# Planning Application Assessment – Delegated Report

**Planning Application Reference** : PL/2021/03311/PPFL

**Address** : Pear Tree Farm Meer End Road Meer End Solihull

**Proposal** : Replacement of an existing residential annex to Pear Tree farm.

Title:
- Existing Elevations

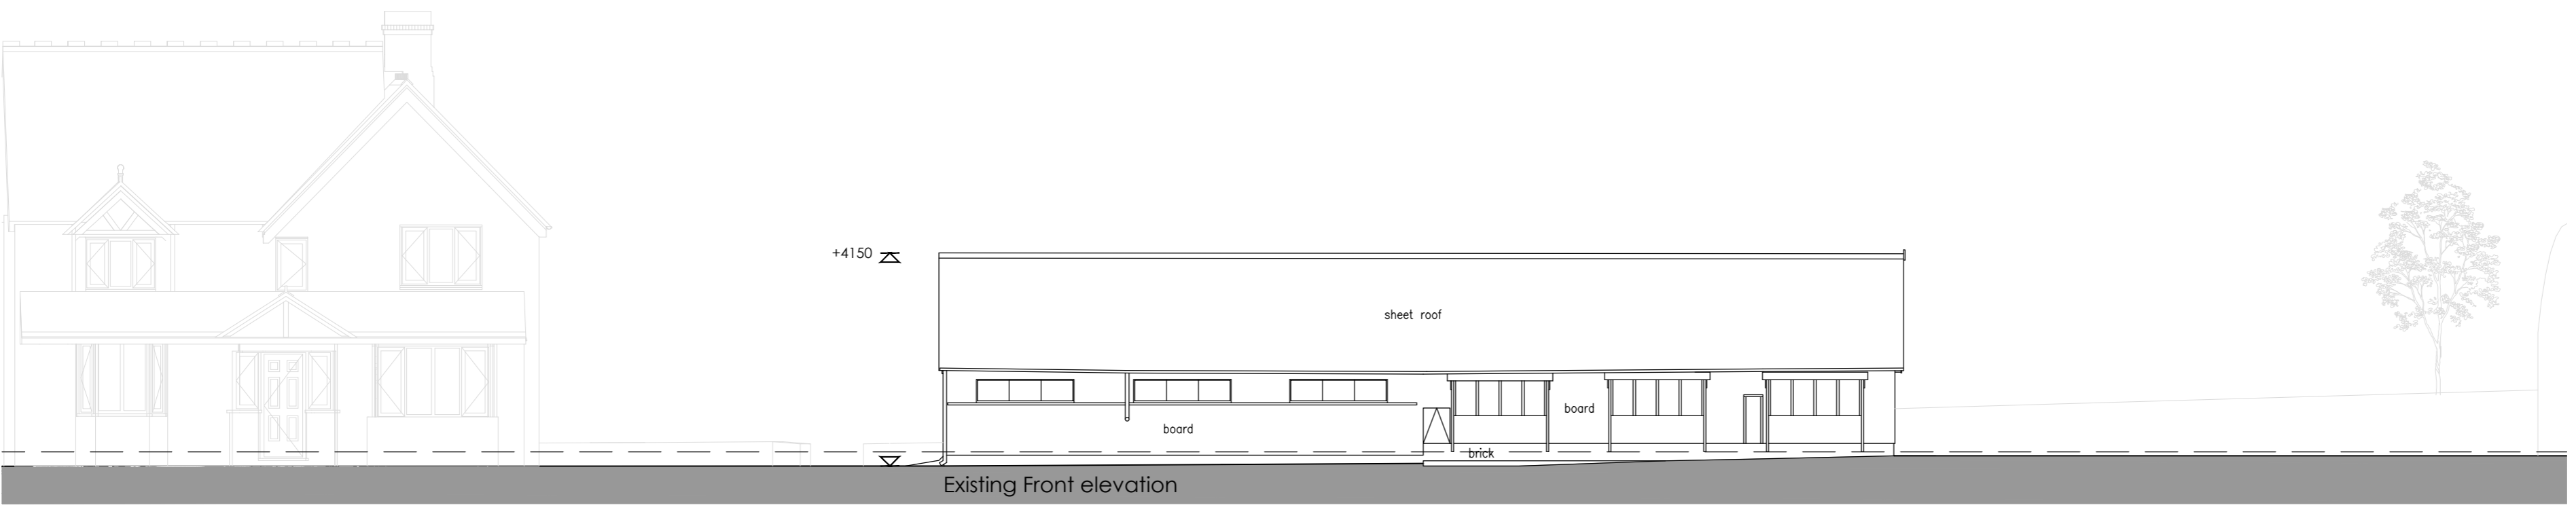
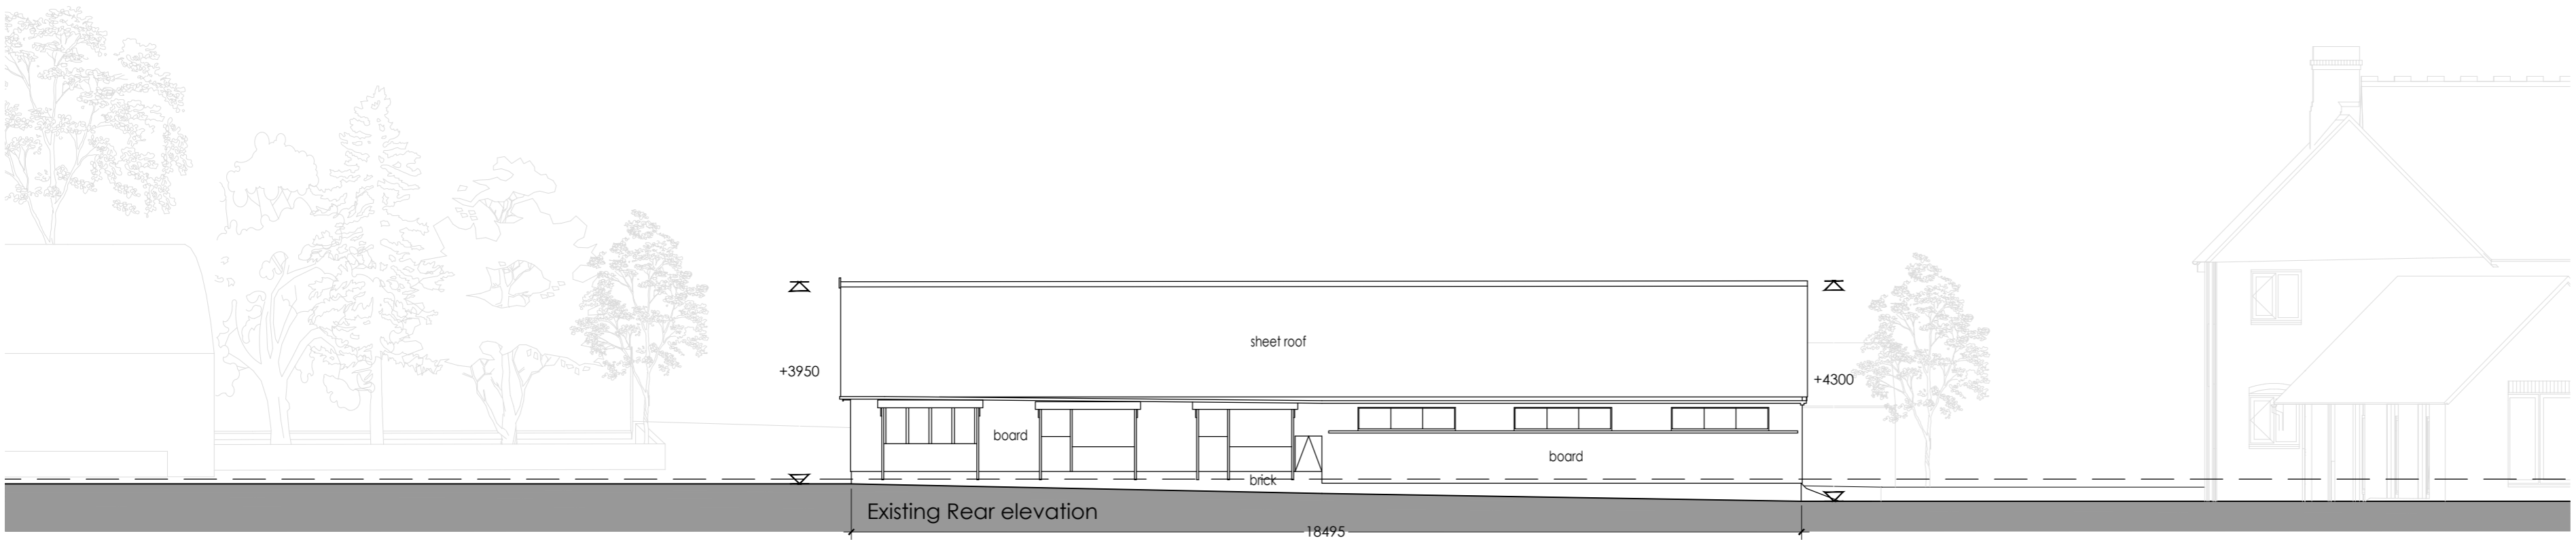
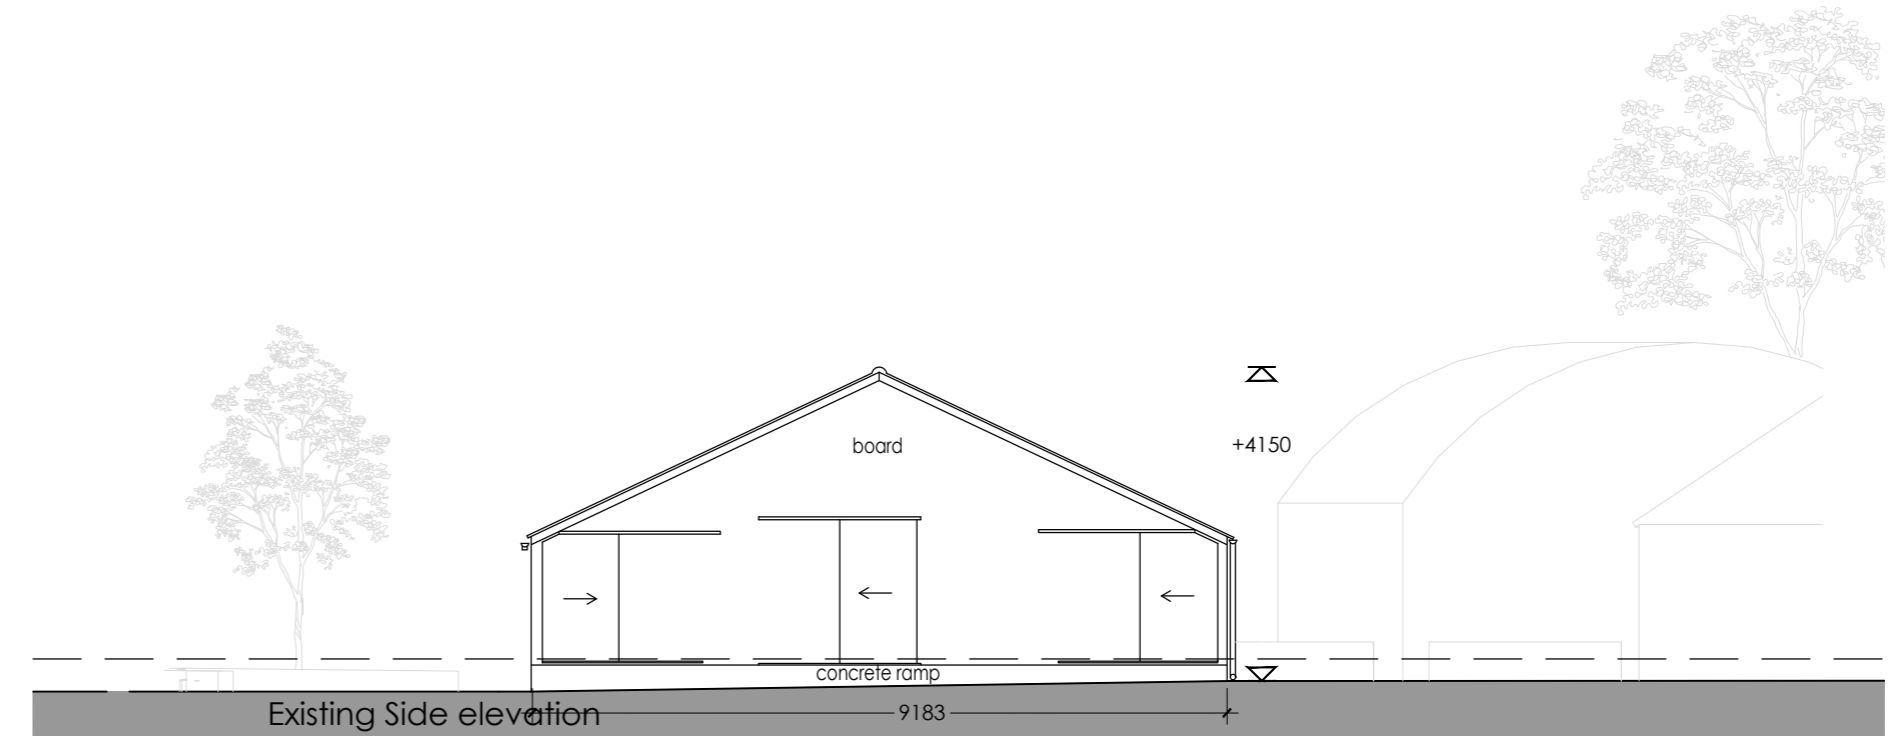
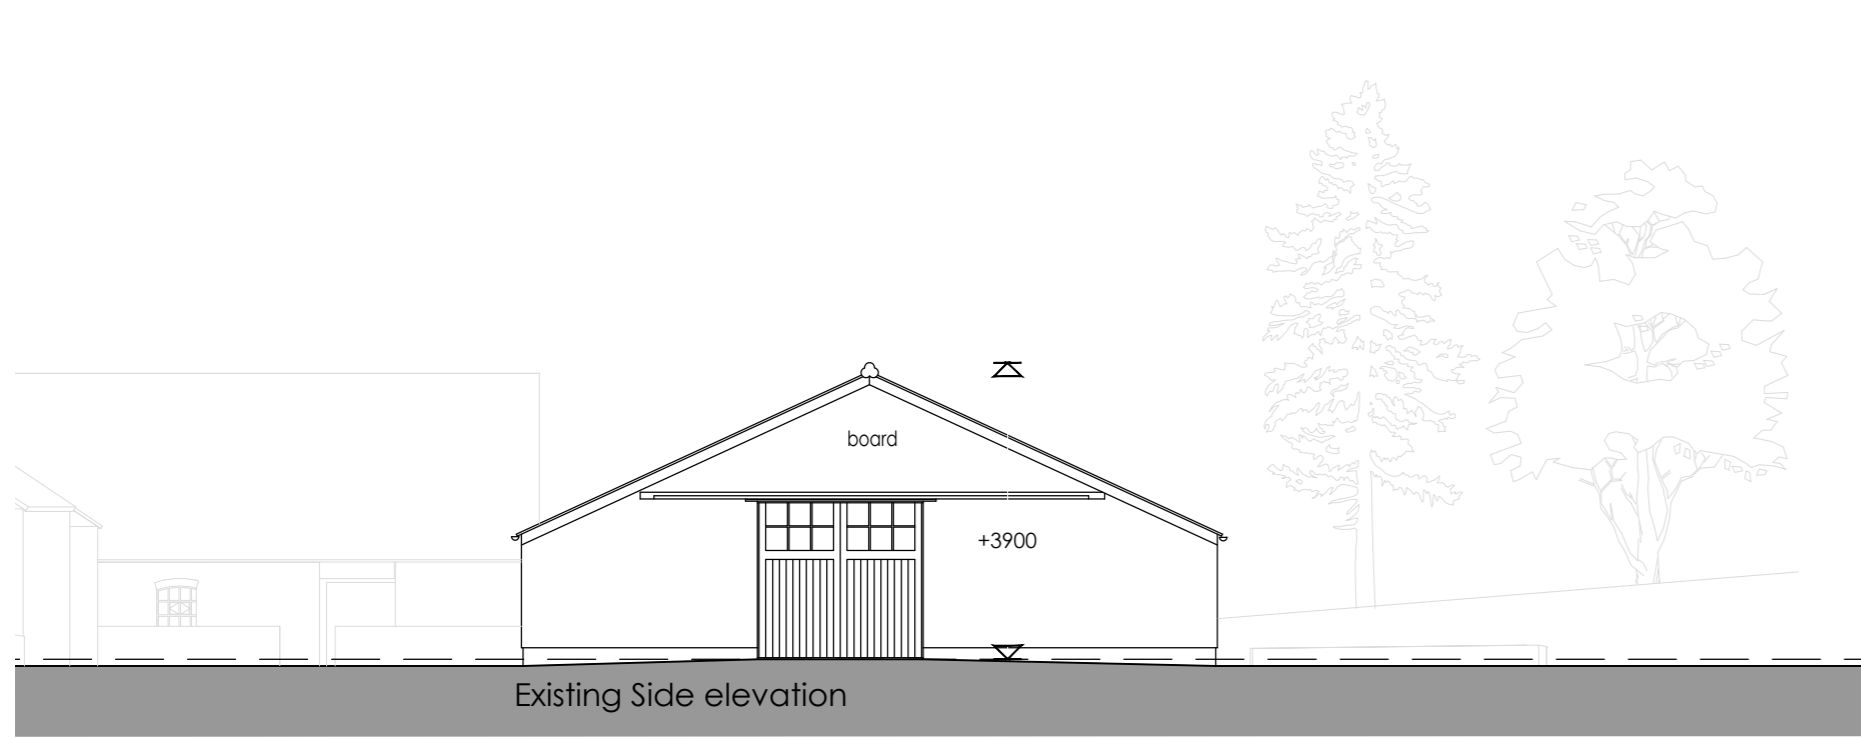
The existing building appears not to have been extended and the proposal will increase the eaves height from approximately 1.8m to 3.9m and the ridge height from approximately 3.9m to 5.5m tall. The volume of the existing building is approximately 481 cubic m and of the proposed replacement building will be approximately 777 cubic meters. The replacement building is clearly materially larger both in terms of its total volume and maximum height of ridge.
